Your Ref: OWPC20776
Our Ref: BR/279/18/HH 03-11-2018
Please ask for:
Amber Willard

single storey rear extension.
new second floor dormer roof to provide master bedroom suite.
alterations to front elevation, including replacement garage, porch to front door, new
slate roof finish, raised roof eaves to provide enlarged first floor and rendered and
horizontal weatherboarding to front and rear elevations.

Blakeney Cottage Sylvan Way Bognor Regis

Re: Opposing Planning Application BR/279/18/HH for Blackeney Cottage, Sylvan Way, Bognor Regis.

**PROPOSED
ELEVATIONS**

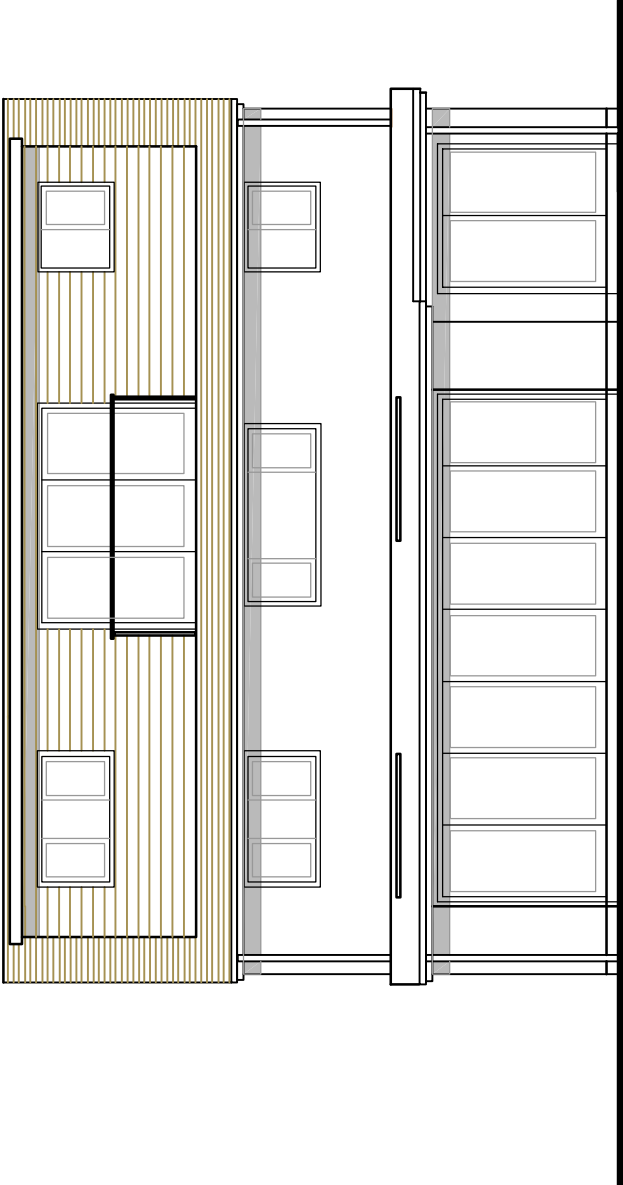
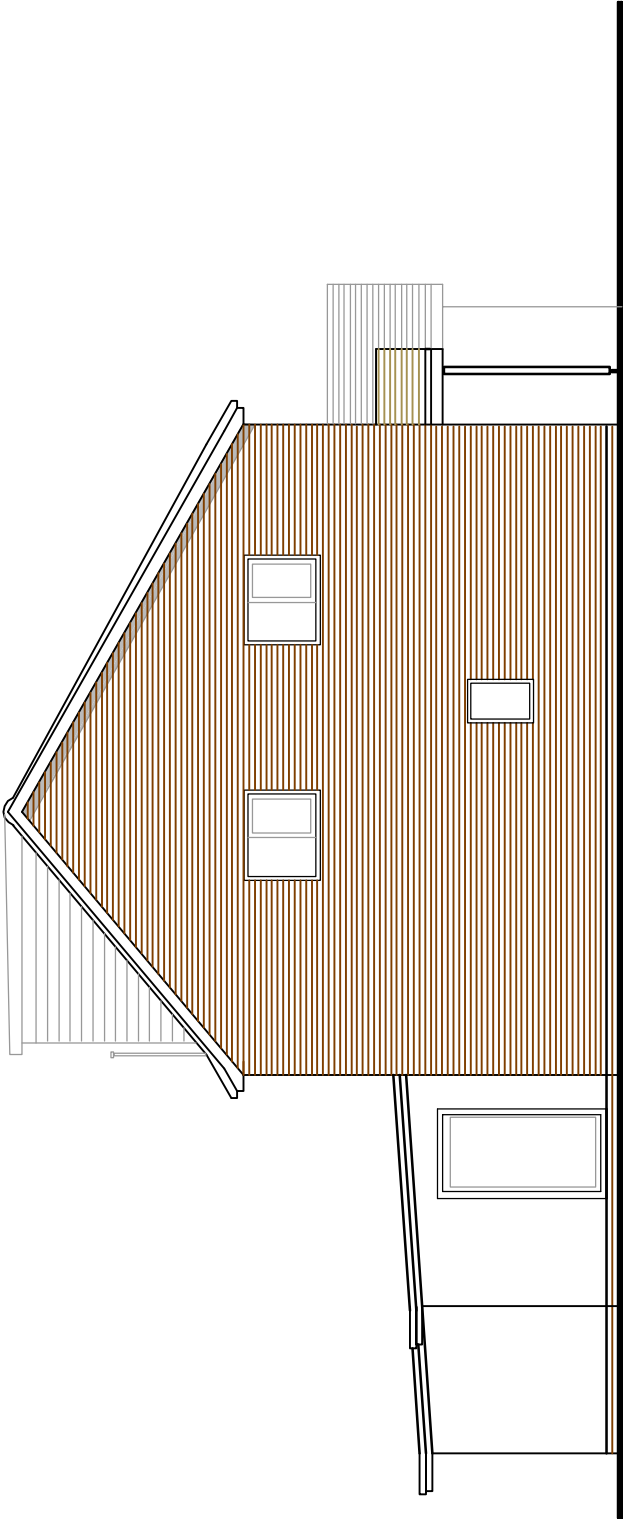
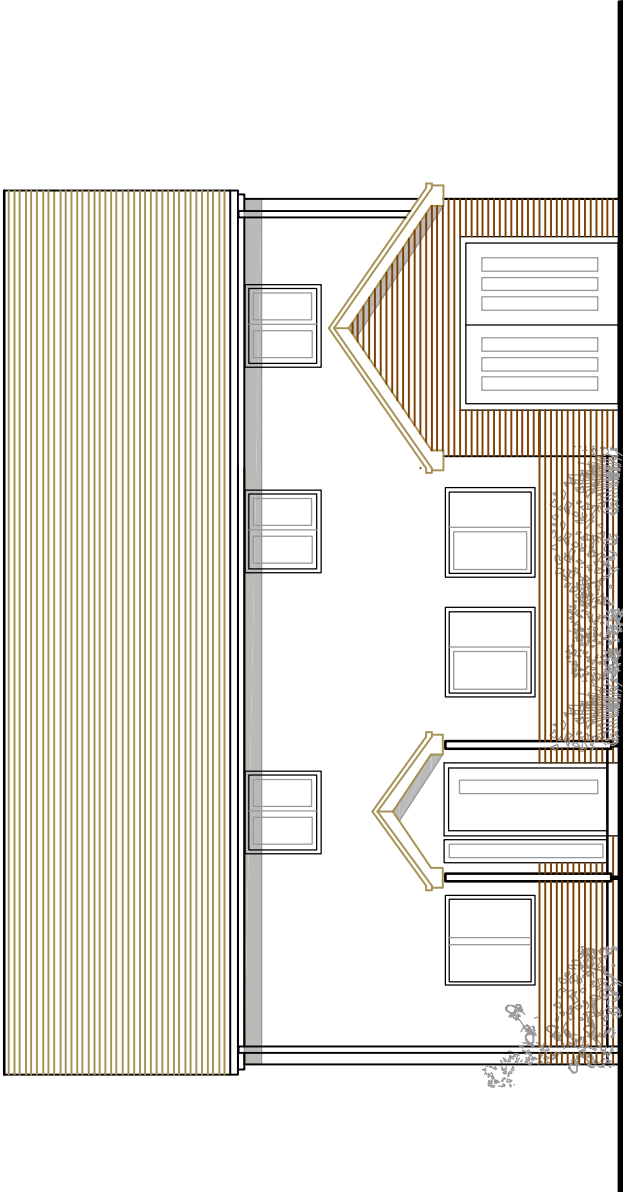
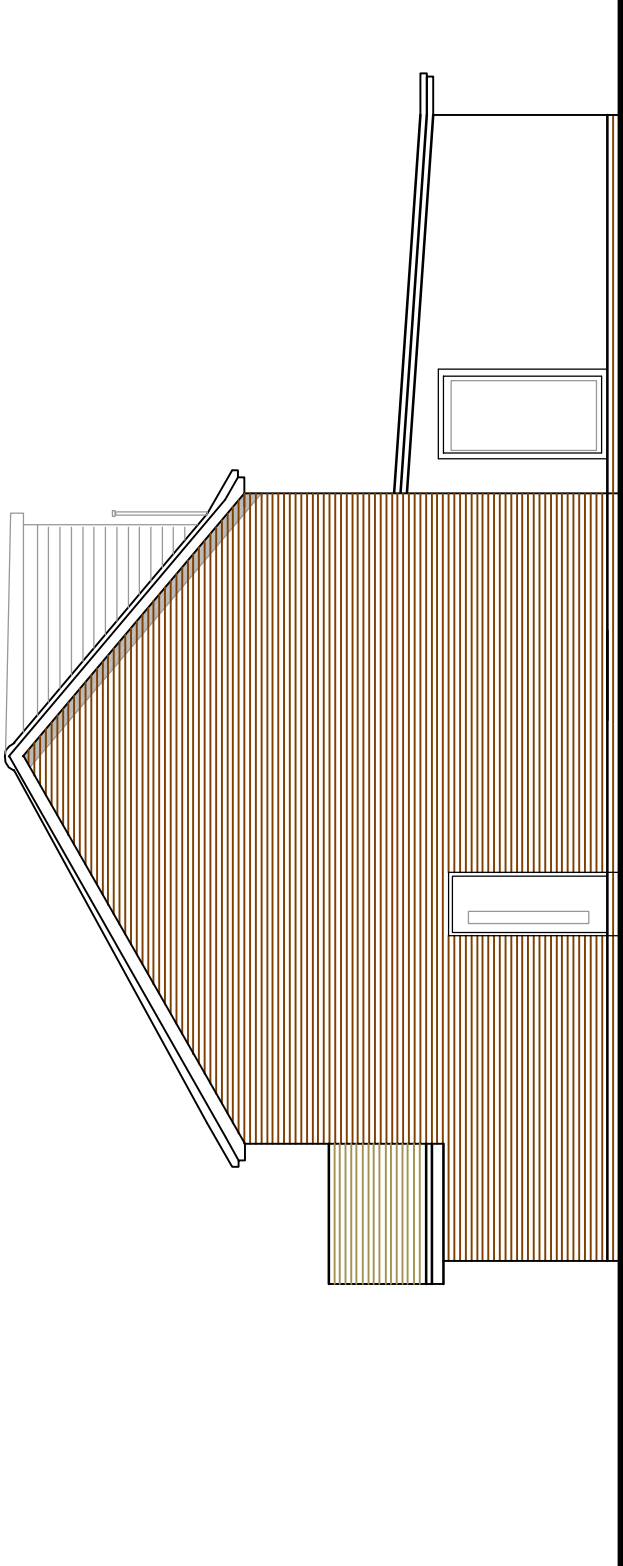
The tradition of red roof tiles and red brick has been sympathetically used for all other properties within road, and weatherboard cladding would not be as aesthetically appealing, or traditional. In regard of a slate roof all other houses in the area are traditional red tiles again would not be in keeping. The house design of Blackeney Cottage would not be in keeping with the older traditional style of the road where other properties have taken this into consideration.
